Re: Railway works and all works necessary to eliminate and, where necessary, upgrade seven numbered level crossings and carry out all associated and ancillary works along a 24-kilometre section of the Dublin to Cork Railway Line.
Fantstown, Thomastown, Ballyhay, Newtown, Ballycoskery (Ballyhea Village), Shinanagh and Buttevant, Co. Cork and Co. Limerick.

Re: Dublin to Cork railway line; elimination and upgrade of Level Crossings
between Limerick Junction and Mallow Order 2021.

MHL Project Number:	21092TT
Project Title:	Railway Order – Dublin to Cork Railway Line (Elimination & Upgrade of Level Crossings between Limerick Junction and Mallow)
Author:	Brian Murphy, BE CEng MIEI
Date:	30/06/2021
Subject:	Third Party Submission – Dr Michael Kennedy & Dr Deirdre O'Reilly
Document Status:	Draft Internal / Not for Circulation

Figure 2.15: XC219 Buttevant Proposed Realignment

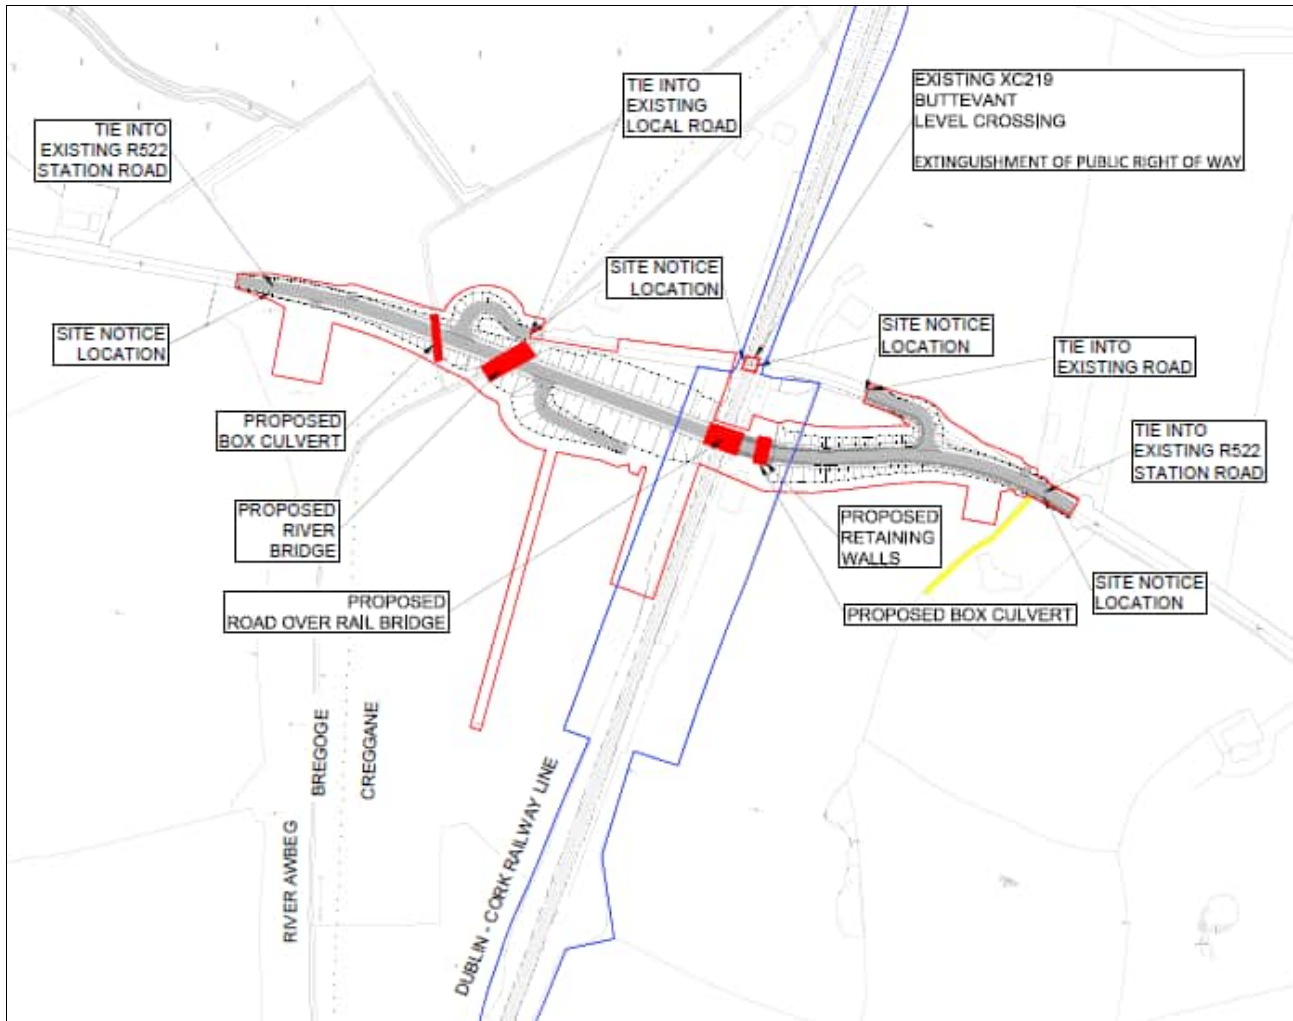
It will be noted from Drawing 1 that it is proposed to re-route the road, particularly, the section between B and C, closer to our Clients' house.

It will also be noted that whereas the existing road is either level with or below the level of our clients' property, the new road would continuously rise from the existing level of 87.86m at C to a new level of 94.69 at B (see levels on Drawing 2)

Thus, in the vicinity of our clients' house, the new road would be both closer than and considerably higher than the existing road.

Rather than remain relatively level, traffic would now have to ascend and descend the slopes on both sides of the bridge shown on Drawing 1.

In addition, on the new road, traffic would have to cross the proposed new culvert on our Clients' side of the bridge and the bridge itself which, clearly, would generate more noise than traversing a ground-supported road.

However, were to works to proceed, as will be noted from Drawing 1, vehicles driving Eastwards would, between about the areas marked A and B, be orientated in the direction of our Clients' house.

It is clear that were the works to proceed the combination of the re-routing/re-orientation of the road and the height of it, as outlined above, would result in our clients' property being overlooked, particularly, by vehicles, cyclists and pedestrians on/near the proposed bridge and on the higher sections of the road between B and C.

Our clients house is located approximately 160m from the location of the proposed new railway bridge. The works will result in vehicular traffic traversing the railway line at a significantly higher level. The carriageway is to increase from approximately 88.6mAOD (at the existing at grade crossing) to 94.69mAOD at the new bridge.

Our client is concerned that vehicles, particularly large HGV type vehicles, travelling over the new bridge will overlook their garden and house.

Our client is also concerned at the impact of high-beam headlight glare onto their property. No boundary treatment is referenced along the new road edge, excepting a roadside safety barrier. This vehicle restraint barrier provides minimal protection from headlight glare and will not provide any visual barrier for passing vehicles.

An appropriate high level boundary treatment, located along southern road edge of the new road, should be installed to protect the house owner's residential amenity.

PLAN VIEW 02
Scale (1:500)
View Rotated 0° Clockwise

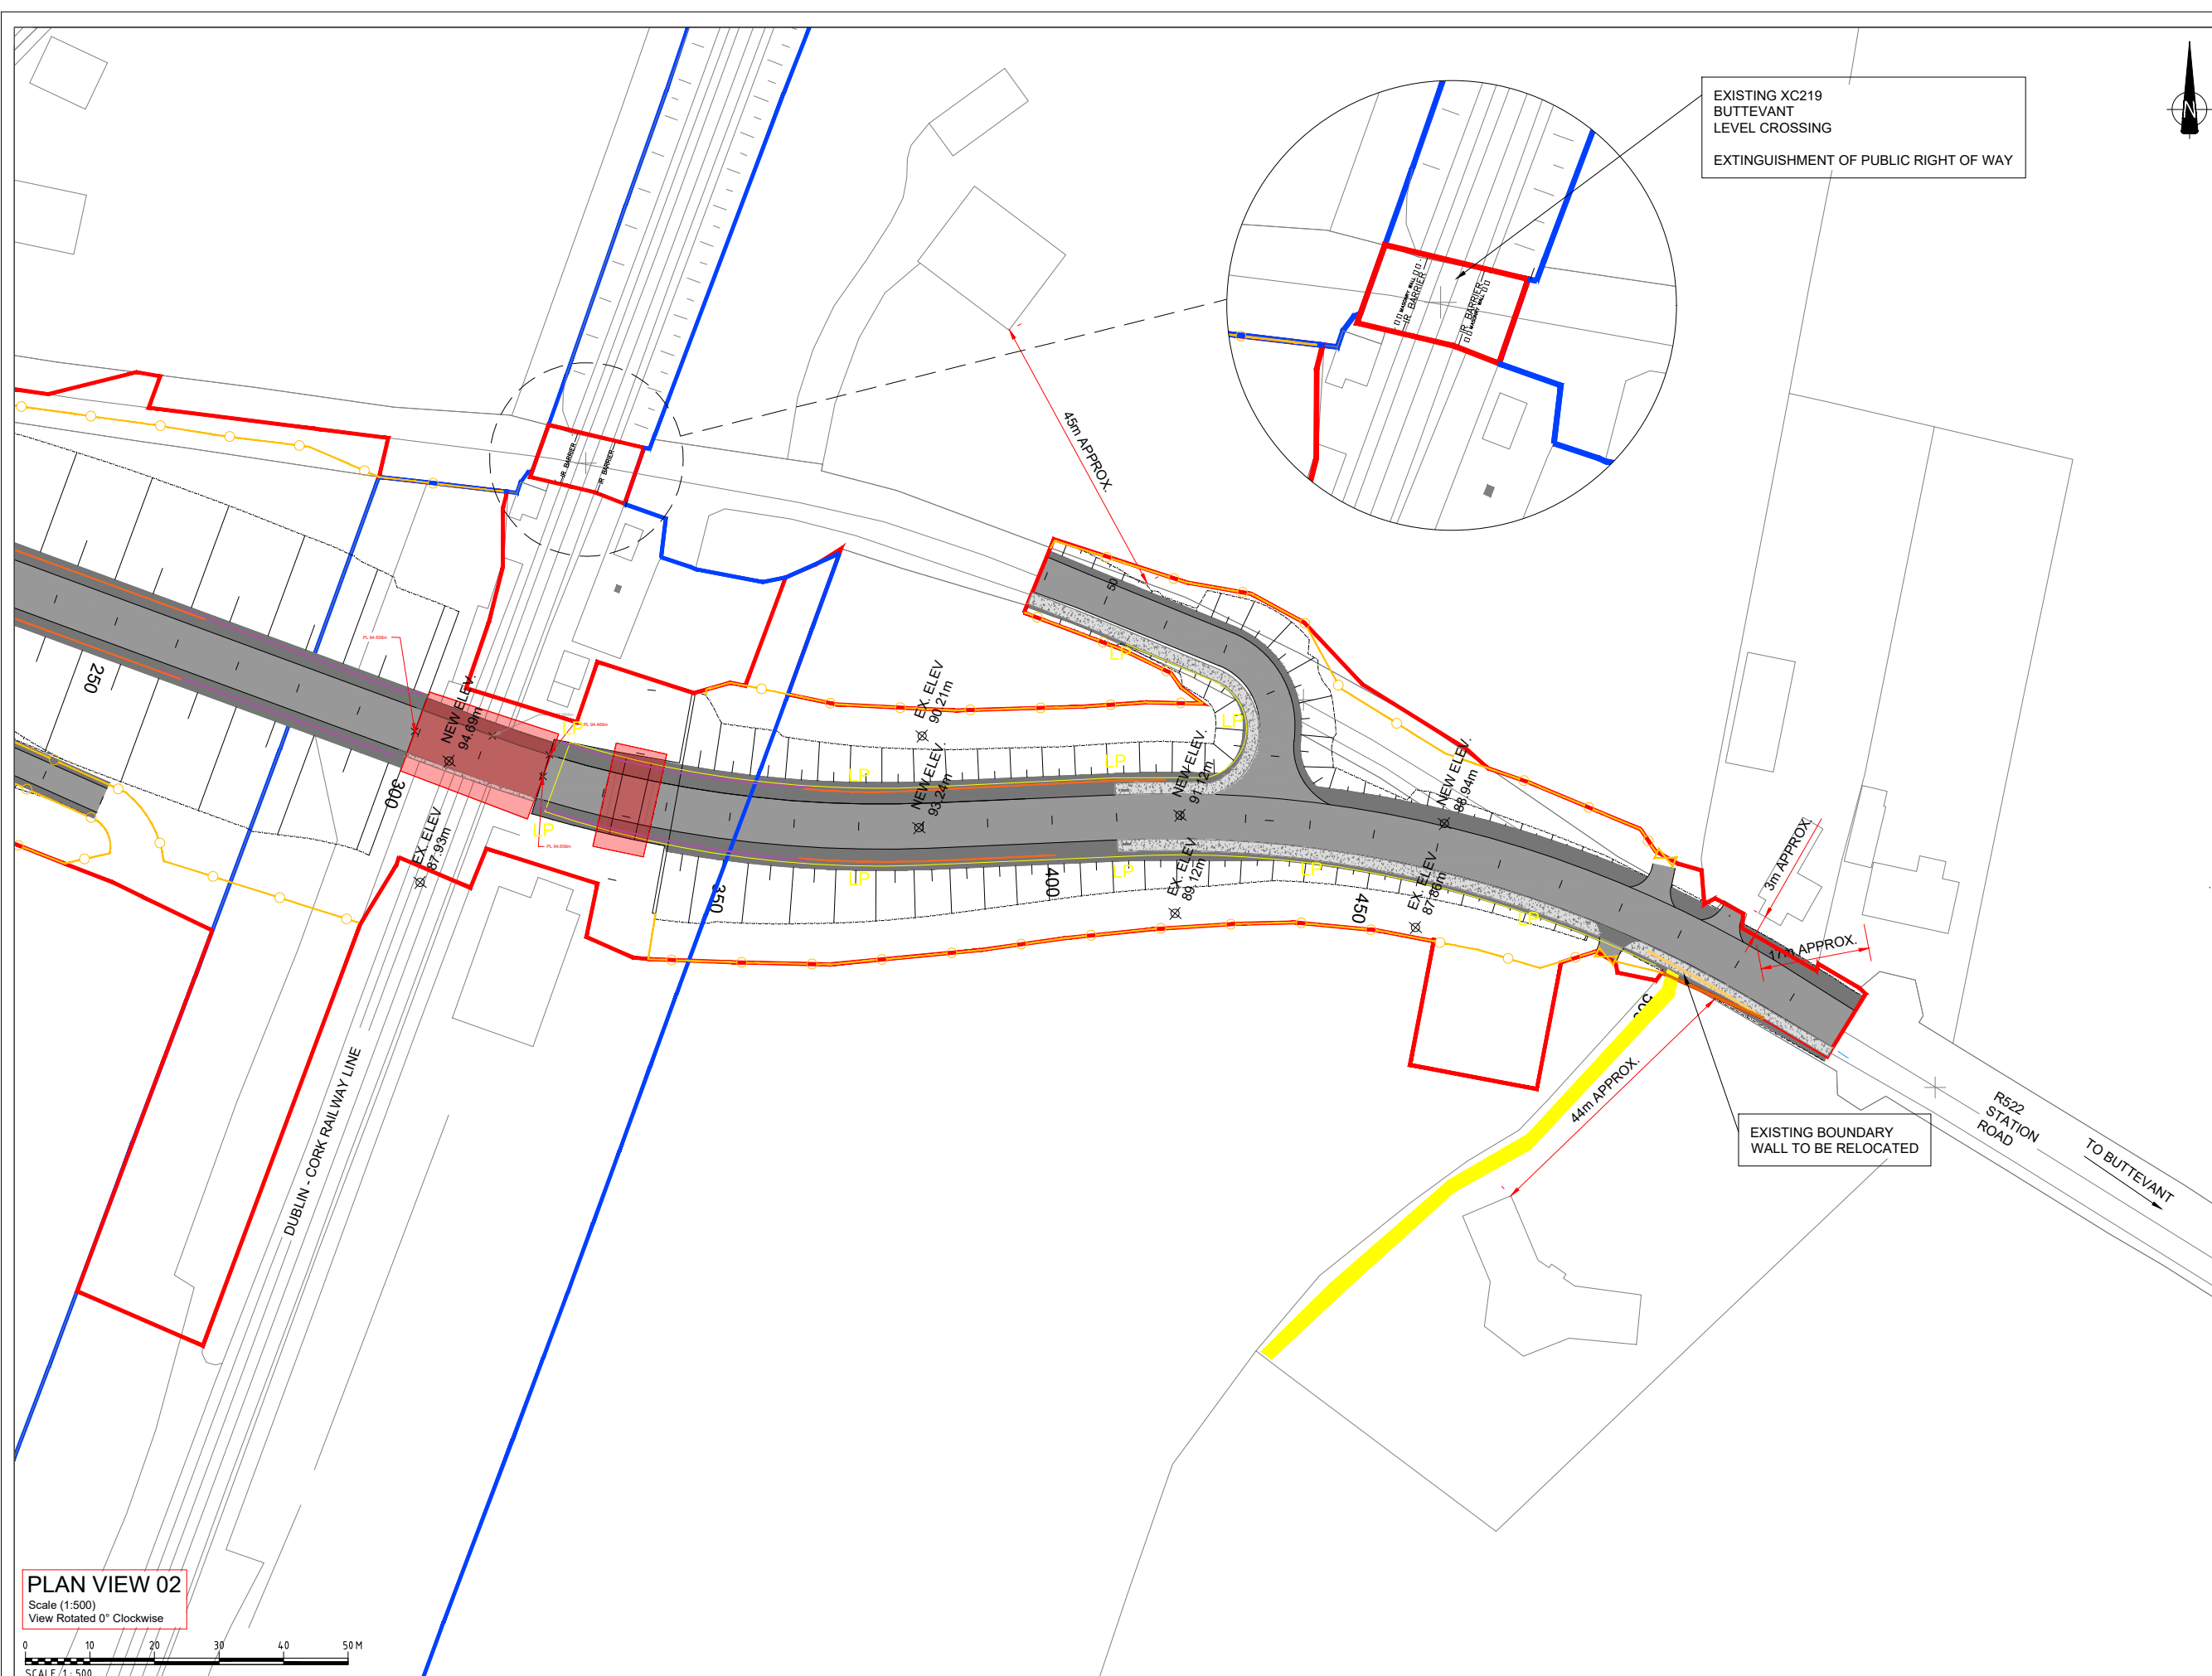
Application drawing (Ref 32111000-JAC-LUH-XC219-DR-CH-0004(ii), Proposed Site Plan - Xc219 Buttevant - Sheet 2 OF 2) indicates that a footpath is to be provided from our client's property northwards. This is unclear and clarity should be provided on same. From chainage 410m westwards a "pavement/verge" is to be provided as far as the bridge. No roadside space is provided over the bridge on the southern side of the road. A reduced "pavement/verge" width is provided on the opposite side of the road. Local residents currently enjoy connectivity northwards as far as railway crossing. Connectivity across the rail tracks and onwards, whilst not formally provided for, is catered for by way of a sympathetic roadside boundary, appropriate to such a residential location.

The proposed road space will present a harsh pedestrian environment, not conducive to a comfortable walking environment. No pedestrian crossing provided for our clients to cross the bridge and so they are cut off from walking northward from their house. Failure to provide safe pedestrian connectivity could lead to pedestrians crossing the road at unsafe location possibly resulting in collisions with passing vehicles.

A safe continuous footpath should be provided through the length of the road alignment to accommodate safe access for local residents along the route.
